Application # 0750018181A

COUNTY OF HARNETT LAND USE APPLICATION
Central Permitting 108 E. Front Street, Lillington, NC 27546 Phone: (910) 893-7525 Fax: (910) 893-2793 www.harnett.org

Re: Status of Improvement Permit Application #07-5-18181 Lt 194

Joe West, R. S.
Environmental Health Specialist
Harnett County Department of Public Health

**NEW CENTURY HOMES, LLC.
THE ROSS
LOT # 194 CRESTVIEW
SCALE: 1"=40'**

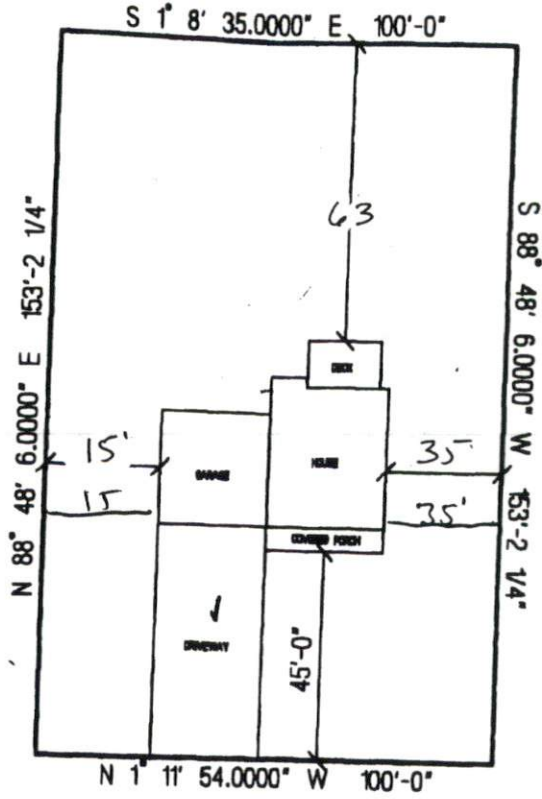
- 1. Property lines/corners not marked or labeled
- 2. House corners not marked or labeled
- 3. Directions not clear to property
- 4. Property needs brush or vegetation removed
- 5. Backhoe pits required
- 6. Other – Please move house as shown on attached sheet, and submit new plot plan to Central Permitting.

Required Residential Property Line Setbacks:		Comments:
Front	Minimum <u>35</u> Actual <u>45</u>	<u>Revision - Per Env. Health</u> <u>No Fee</u>
Rear	<u>25</u> <u>63'-3"</u>	
Side	<u>10</u> <u>25 15 / 35</u>	
Corner/Sidestreet	<u>20</u>	
Nearest Building on same lot	<u>10</u>
